# Marine Management Organisation

MMO Reference: DCO/2021/00003  
Planning Inspectorate Reference: EN010130  
Identification Number: 20048765

## **Planning Act 2008, GTR4 Limited, Proposed Outer Dowsing Offshore Windfarm Order All Interested Parties Consultation 8 and 9**

This document comprises comments in respect of the DCO Application, in response to the request all interested parties consultations 8 and 9 issued by the Secretary of State for the Department of Energy Security & Net Zero on 11 and 19 December 2025, respectively.

Figure 1: [Habitat suitability for \*Sabellaria spinulosa\* reef within the Outer Dowsing Offshore Windfarm Export Cable Corridor \(ECC\) and Inner Dowsing, Race Bank and North Ridge Special Area of Conservation \(IDRBNR SAC\).](#)

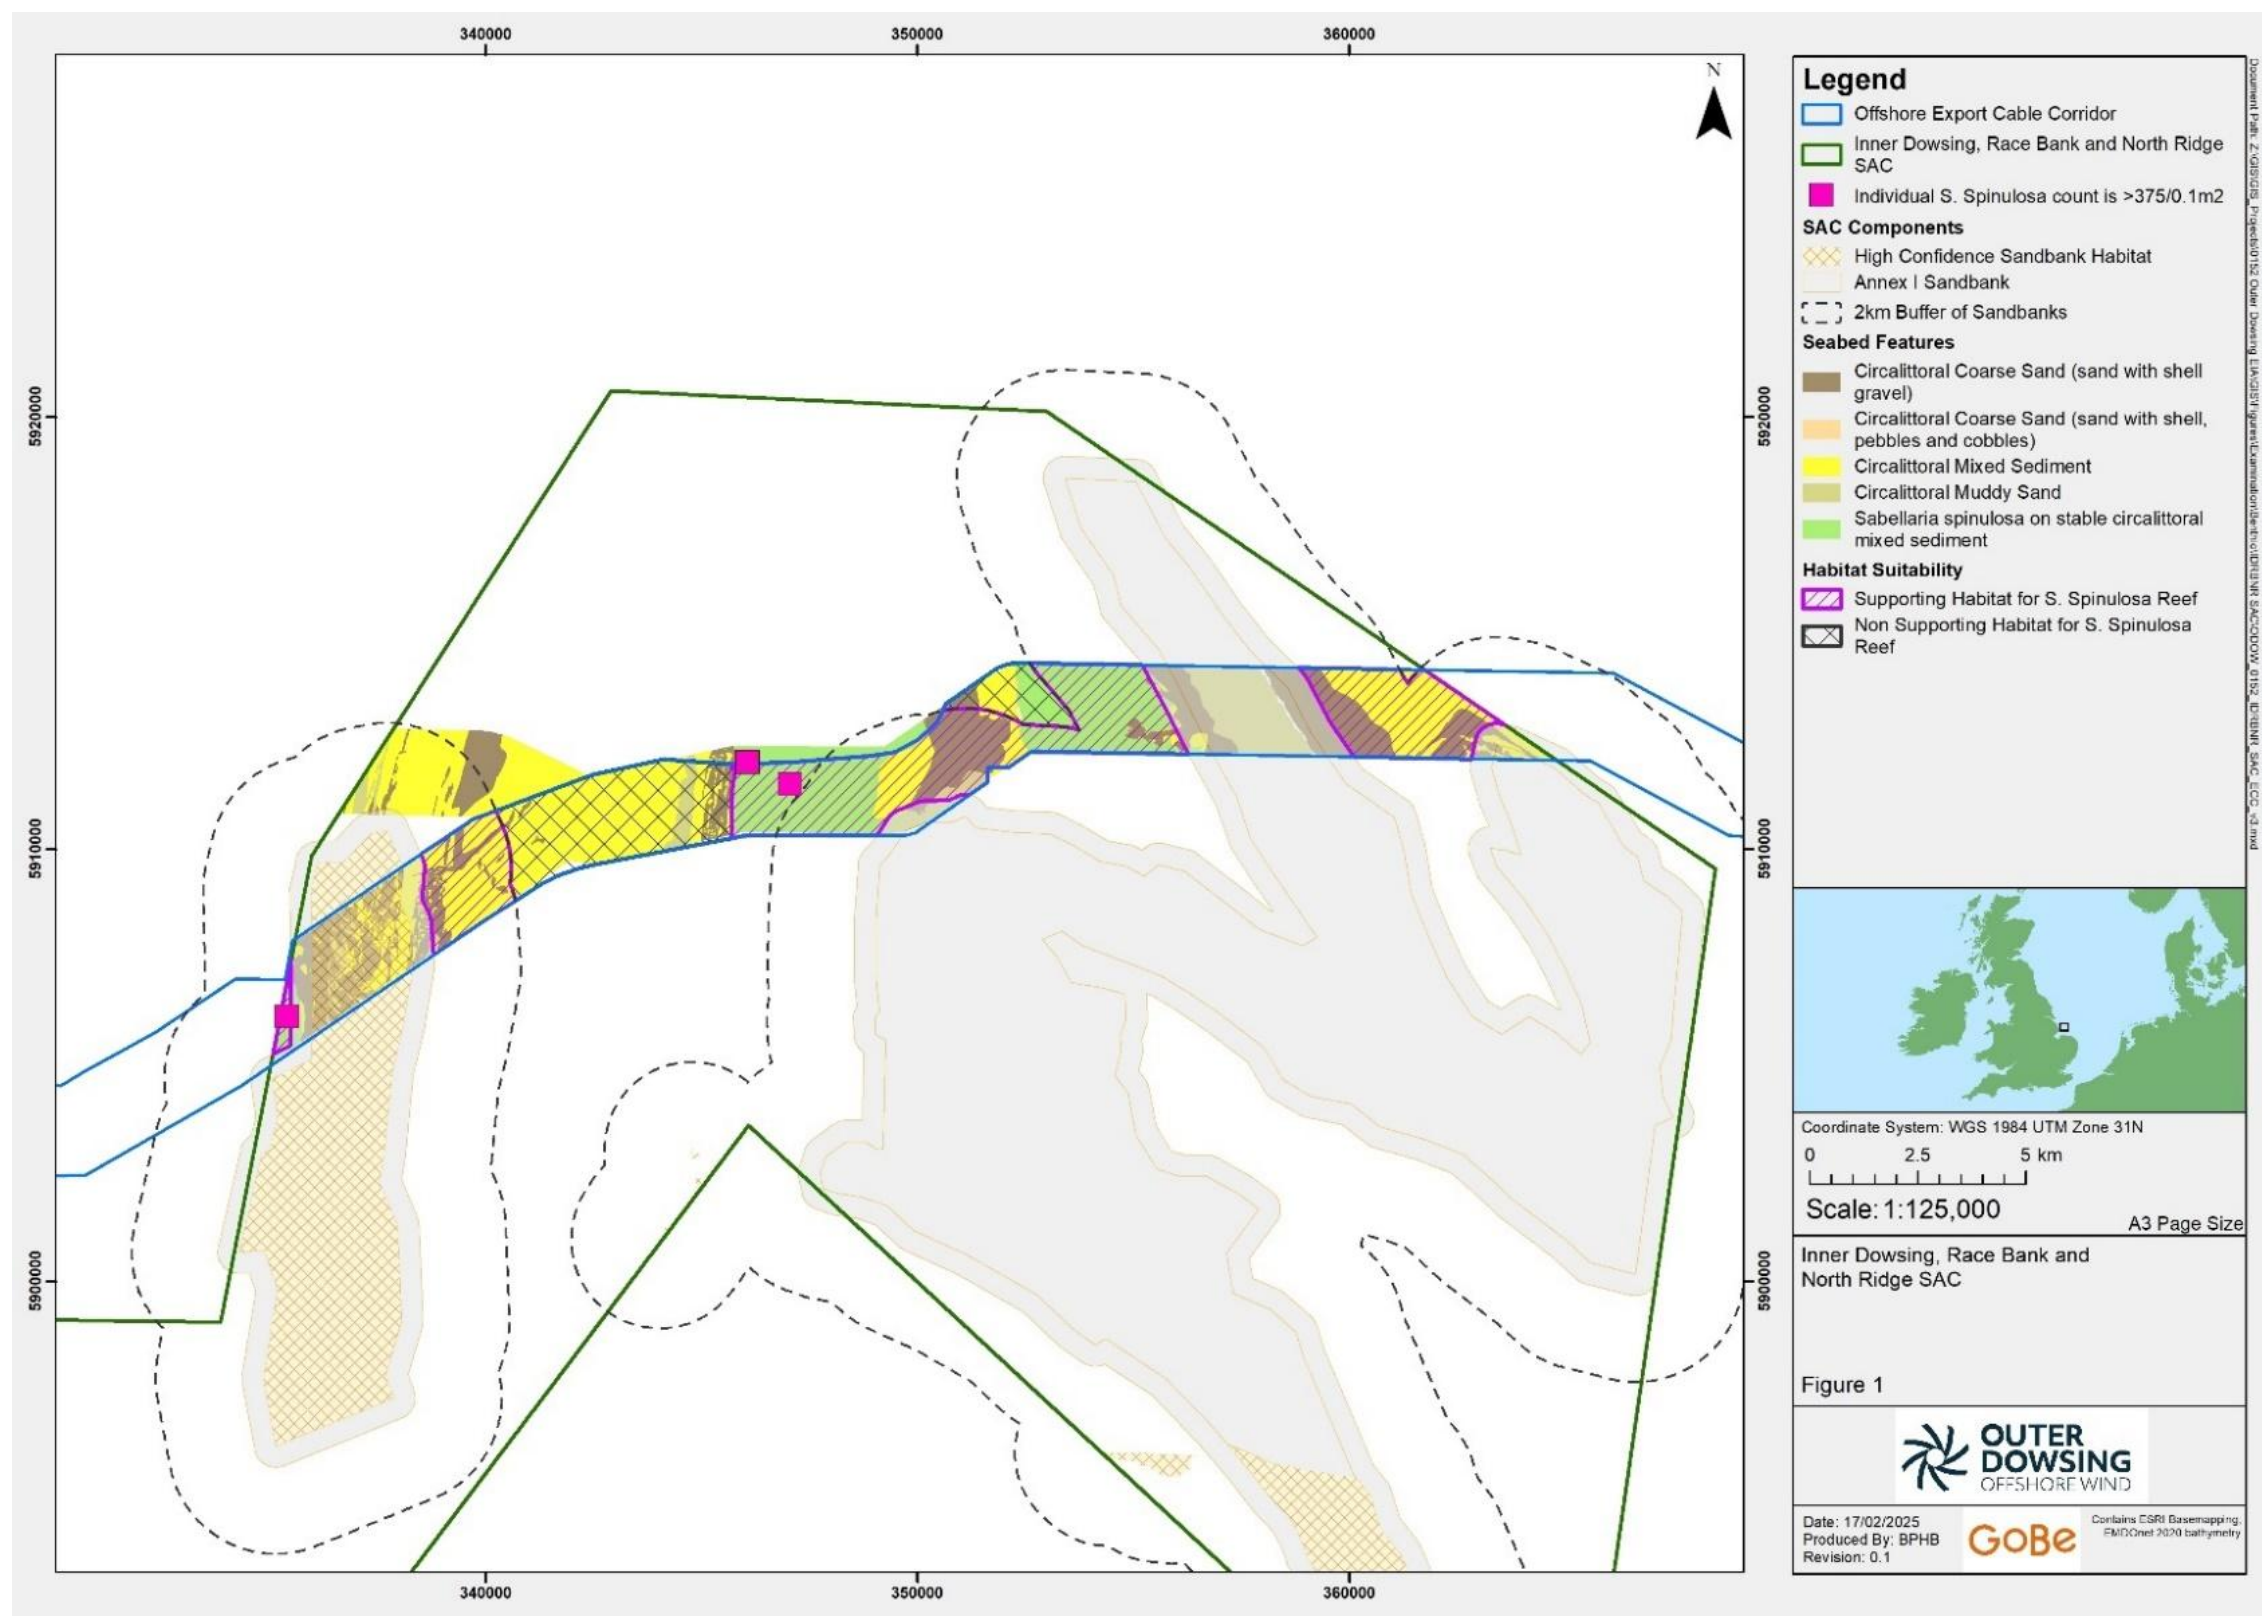
3.1 The MMO welcomes the addition of the section addressing the worst-case scenario impact by square meter footprint for boulder clearance and cable burial activities through areas of supporting habitat for Annex 1 *Sabellaria spinulosa* reef within the IDRBNR SAC, and notes the approach used to include the entire SAC as the number and location of boulders are currently unknown prior to pre-construction surveys being carried out. The MMO advises that the DCO should also be updated with this worst case scenario information.
